Re: Planning Application 20/0573

Address: 29 Glendale Drive Mellor Blackburn BB2 7HB

Description: Proposed first floor extension to existing garage and internal alterations. Resubmission of Planning Application 3/2019/0985.

PROPOSED SITE PLAN 1:200

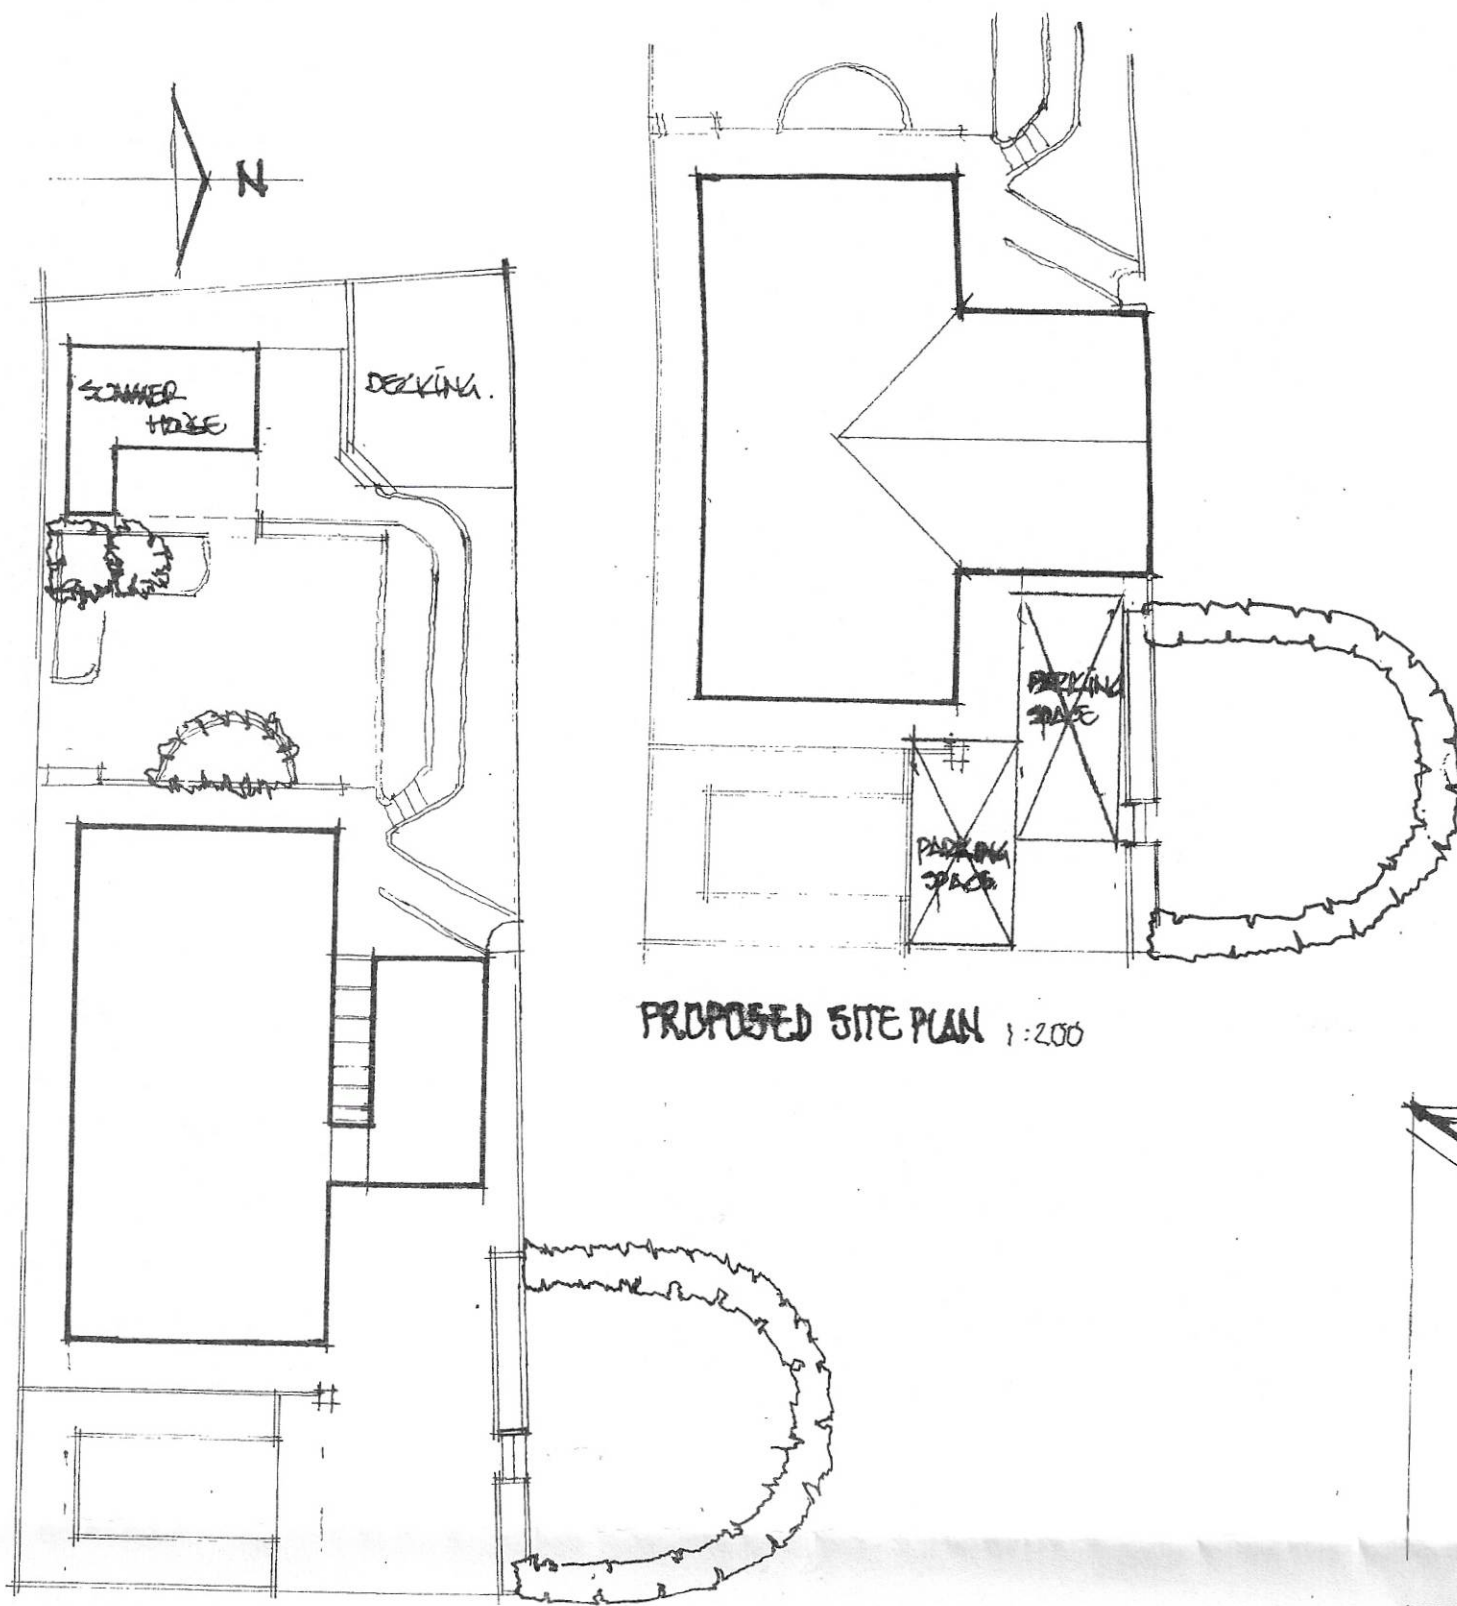
The dwelling is to become a 4 bedrooned house, which according the Lancashire's Parking Standards should have 3 off street parking spaces.

The garage being provided it is considered to be of a suitable size, however the off street parking does not meet the guidance previously issued.

Any off street parking spaces should be at least 2.4m wide and 5.5m long, an additional width of 0.6m should be provided where a space is adjacent to a wall to allow space for the car door to open. Where the driveway is used as the pedestrian access an additional width of 0.8m should be provided.

It is also noted that a previous planning application would suggest that part of this dwelling is used holistic therapy studio. No account of any business parking requirements of such an undertaking have been made.

In order to support this application we would look for further plans showing how the parking requirements can be accommodated. It may be necessary to widen the driveway access by way of lowering additional kerbs.
